Grittleton Parish Council Responses to Relevant Representations. (RR1742)

Scale: 1:30,000 @ A3

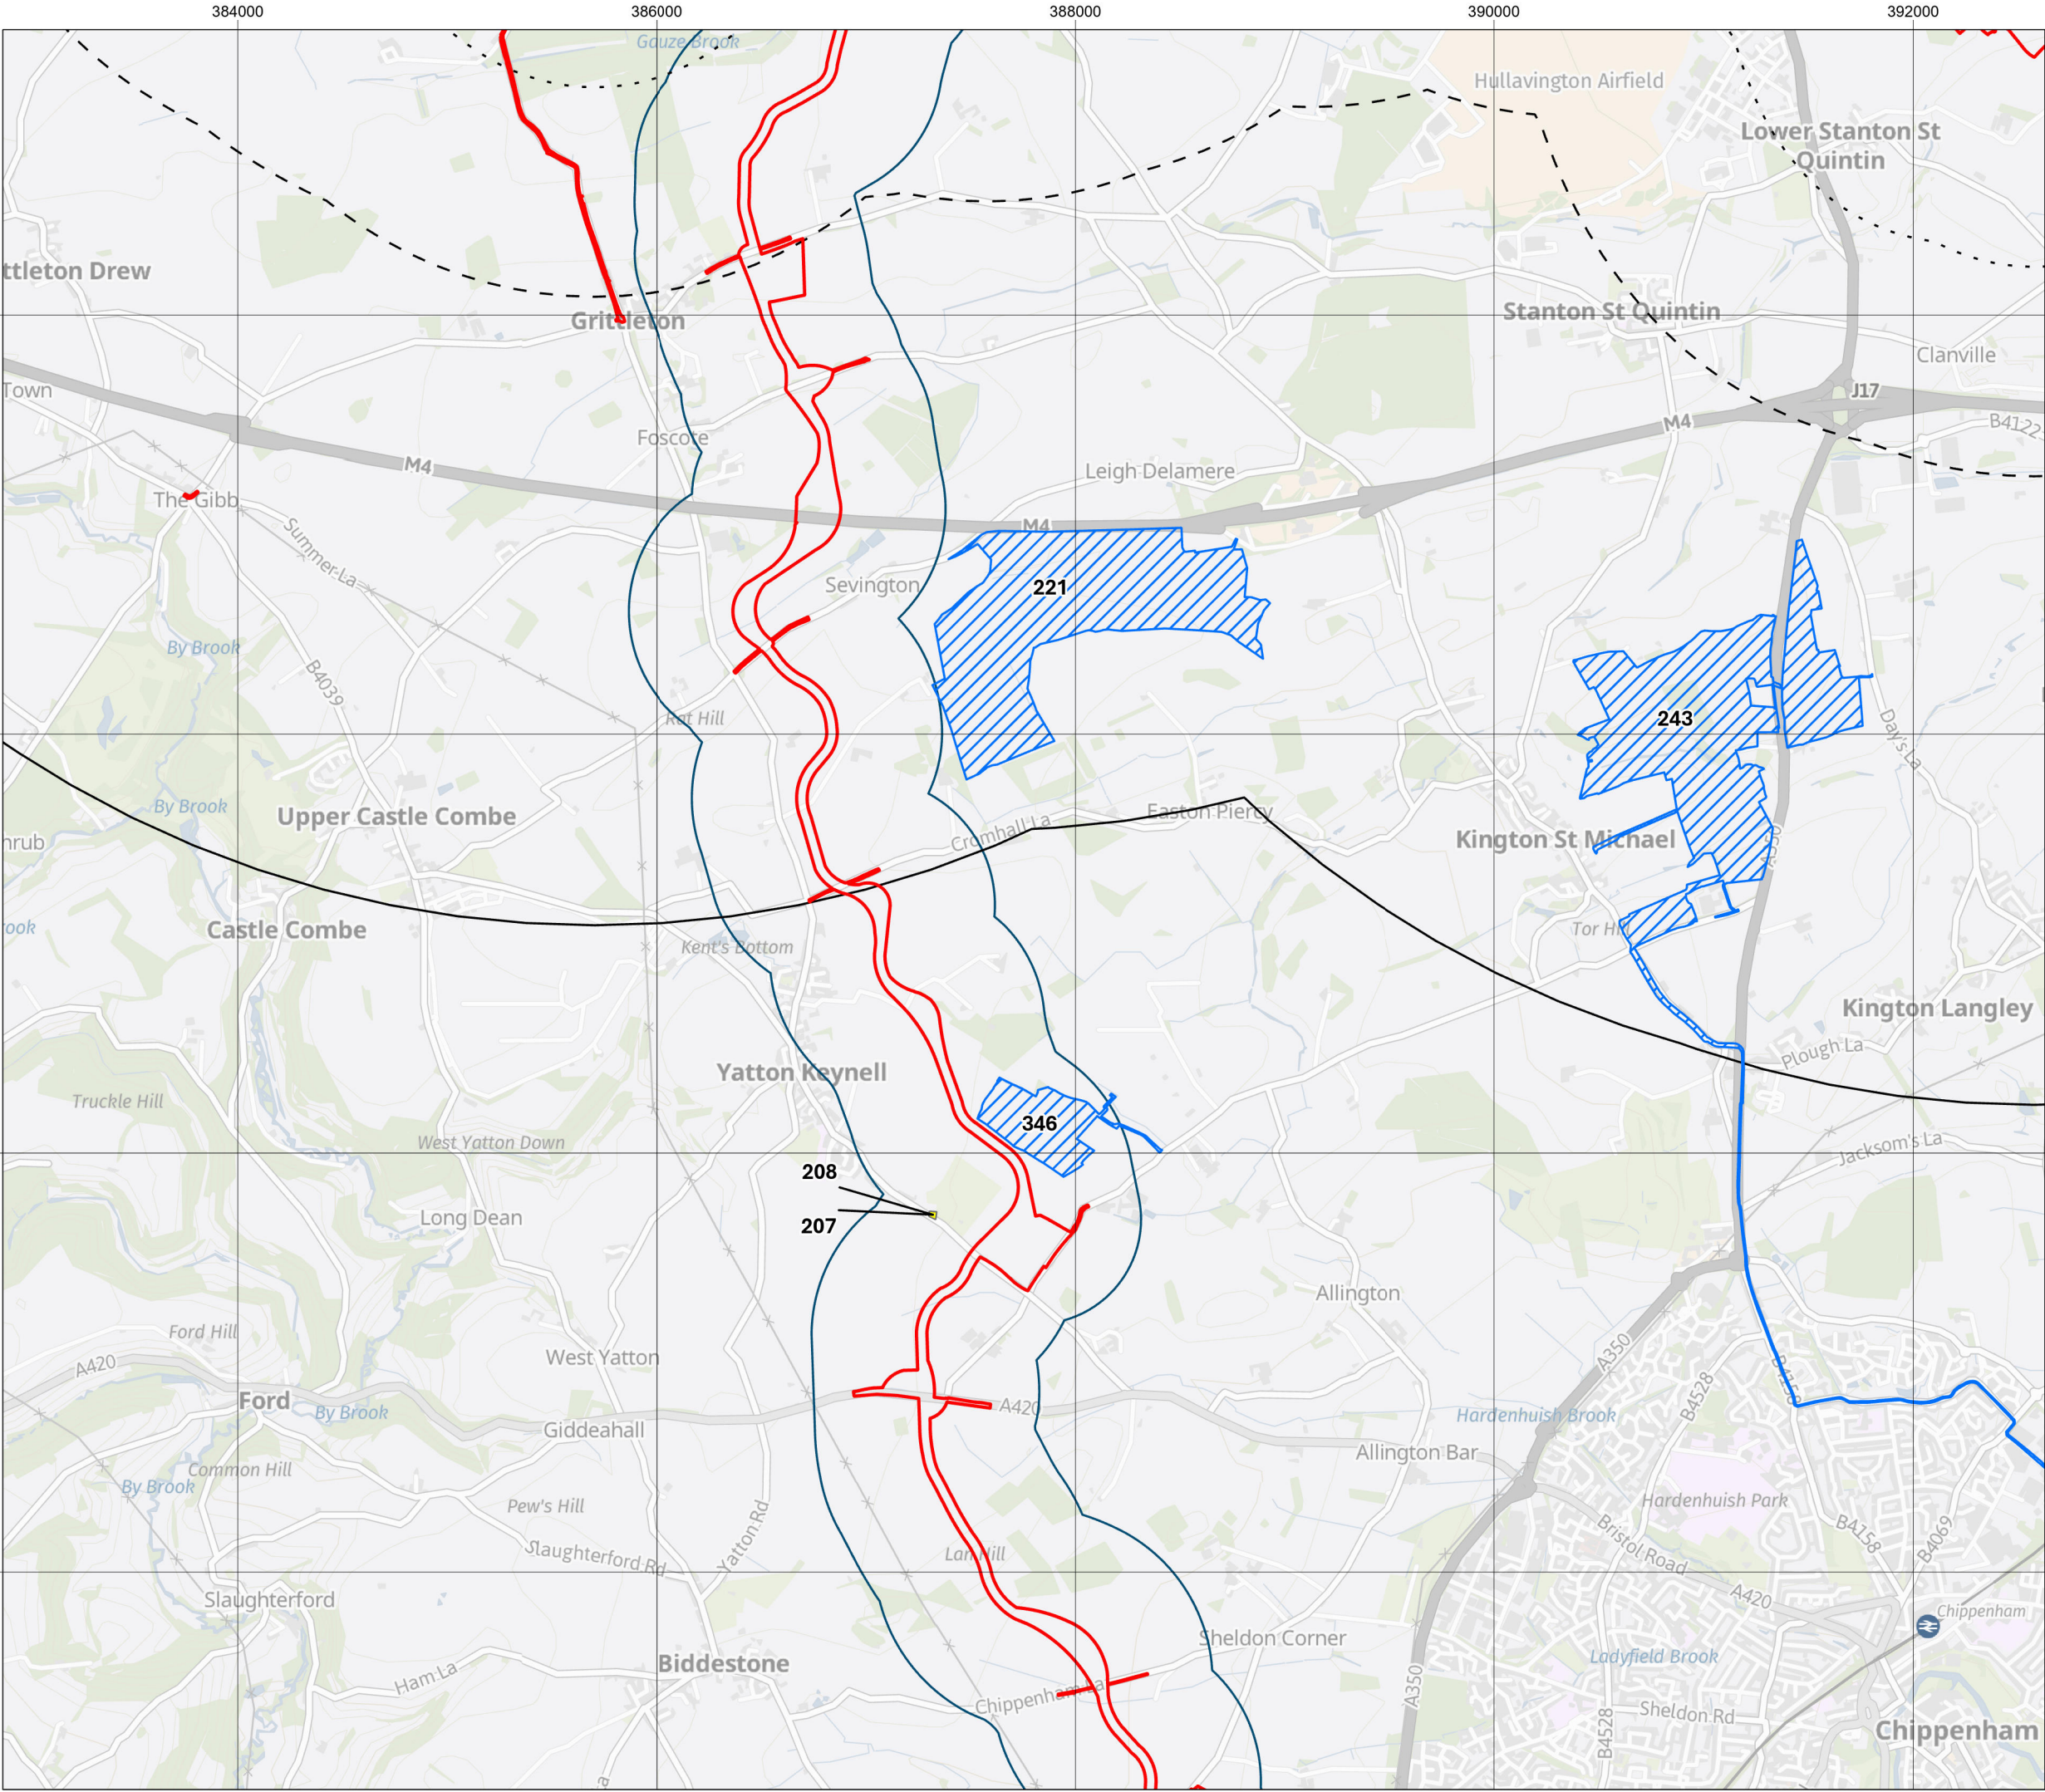
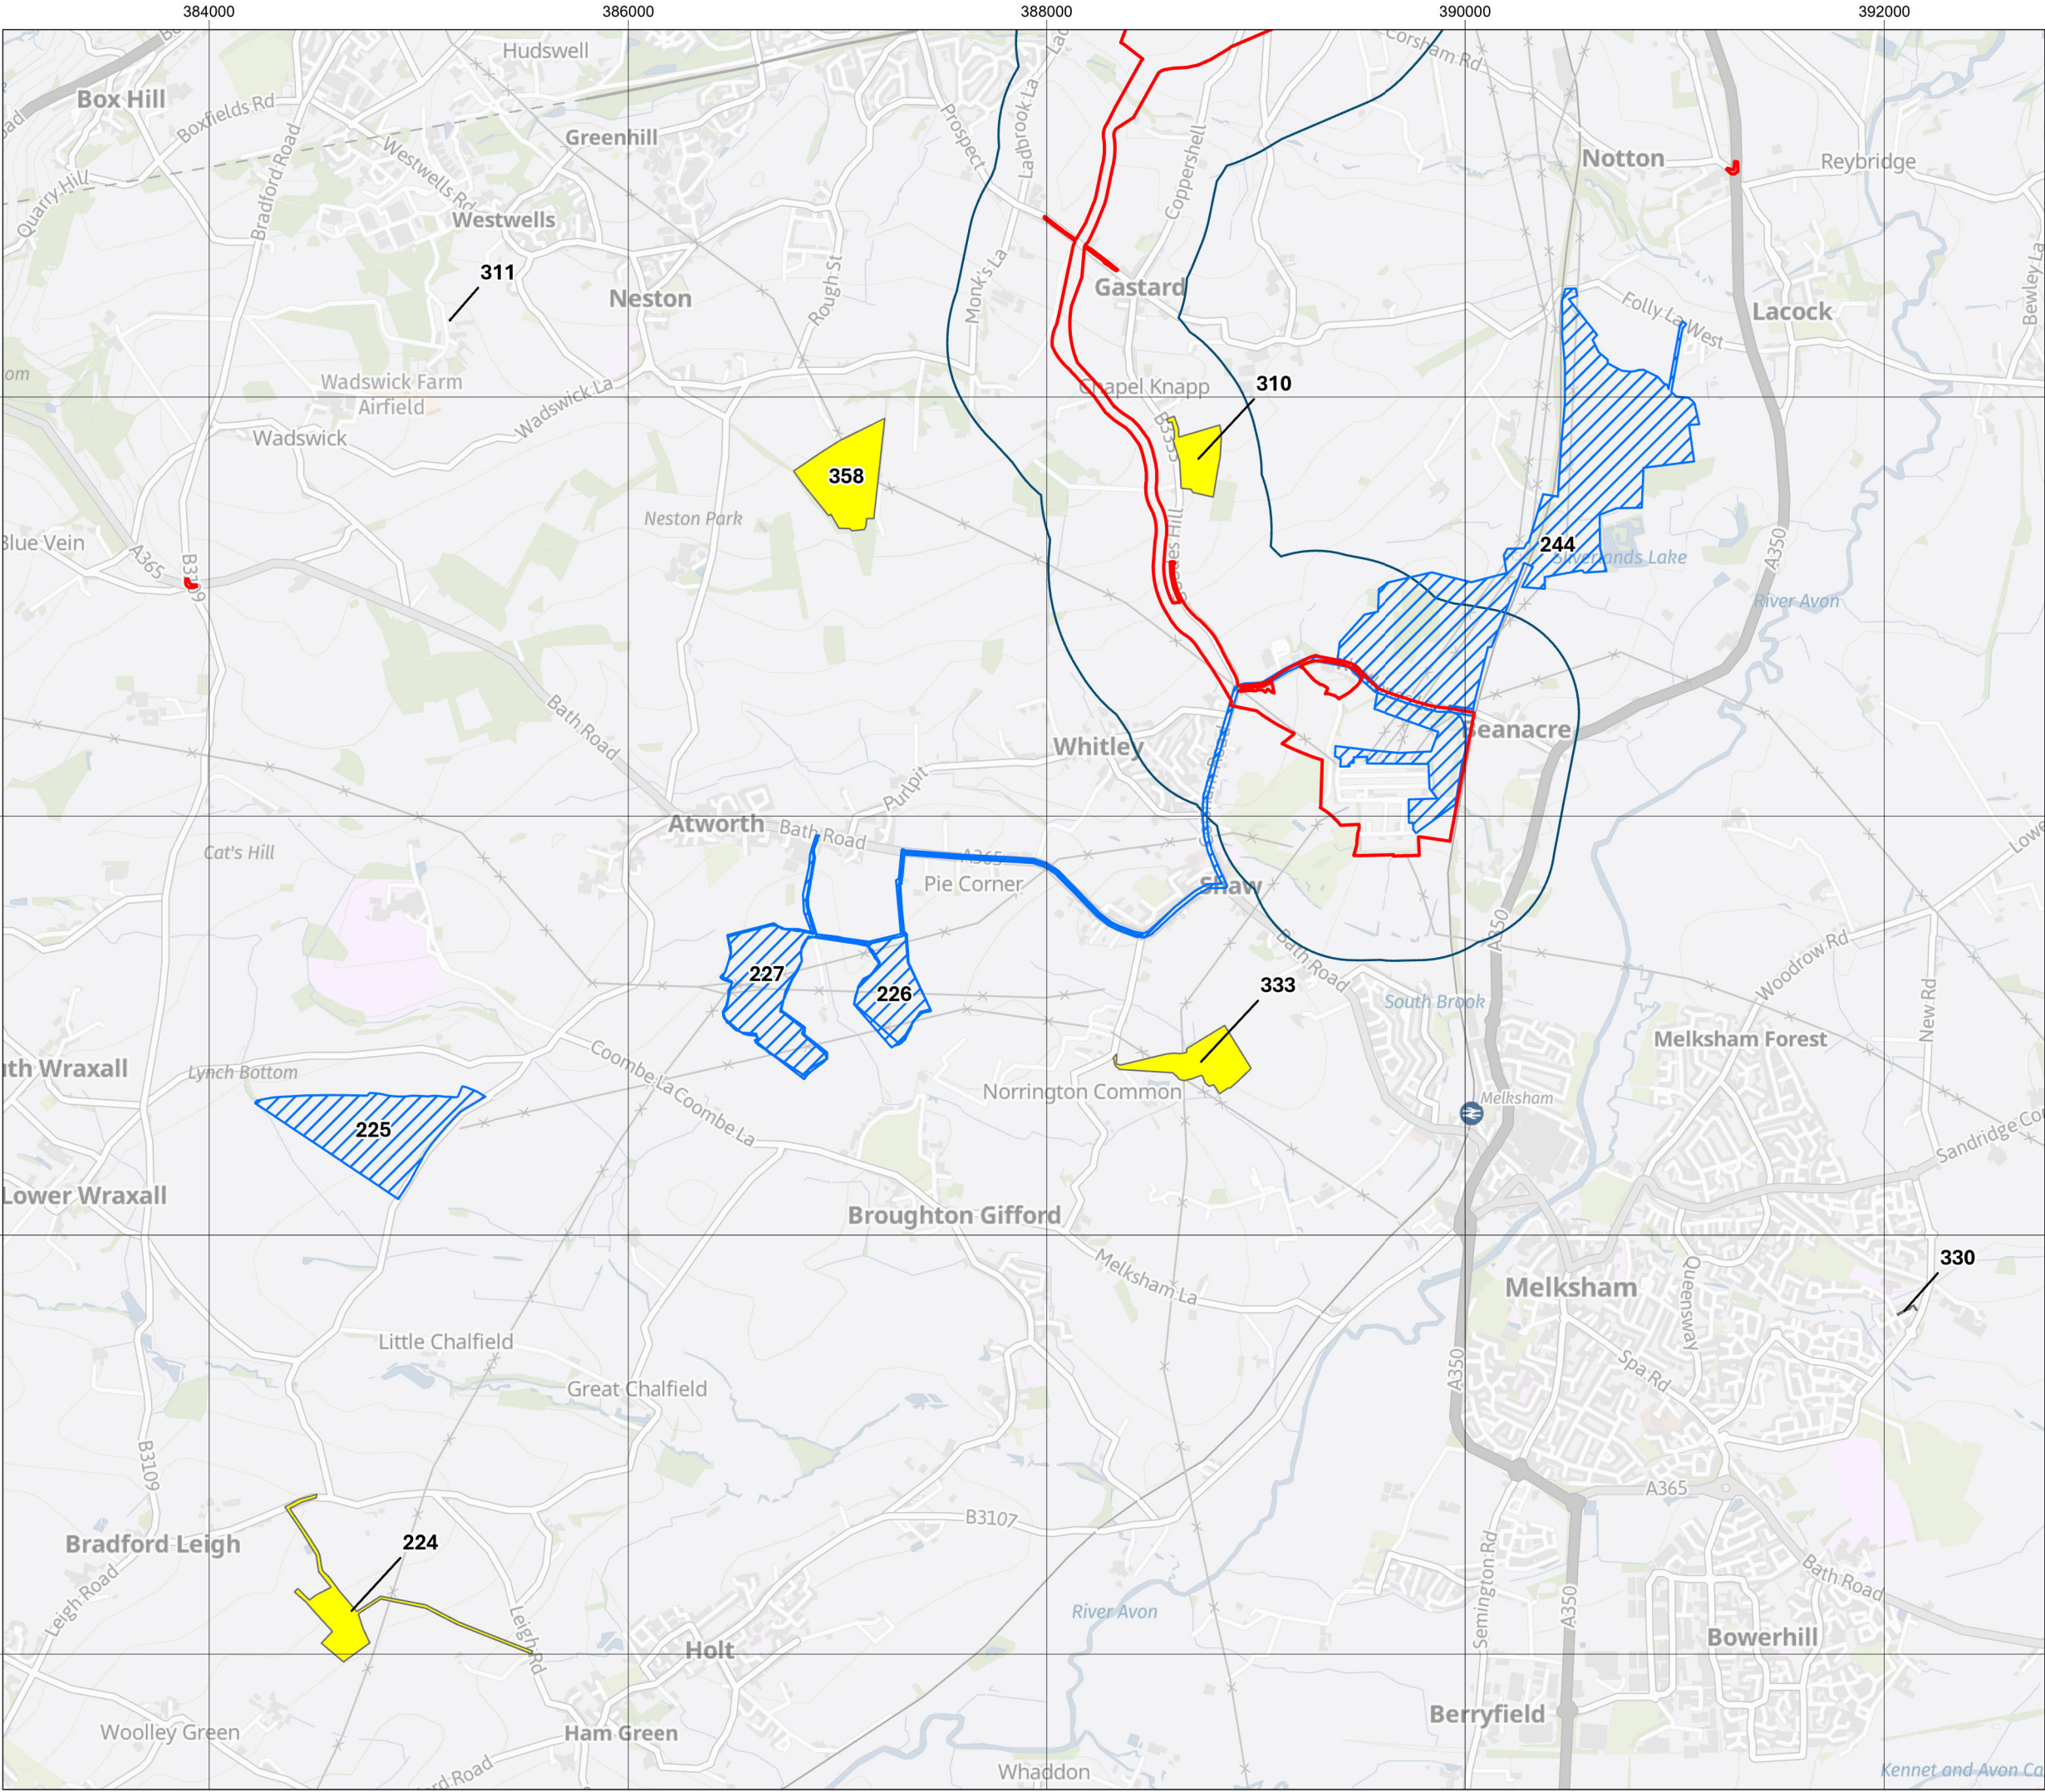
GPC – 004 – Cumulative impact, the 10km study area is too restrictive and should be extended to 20km.
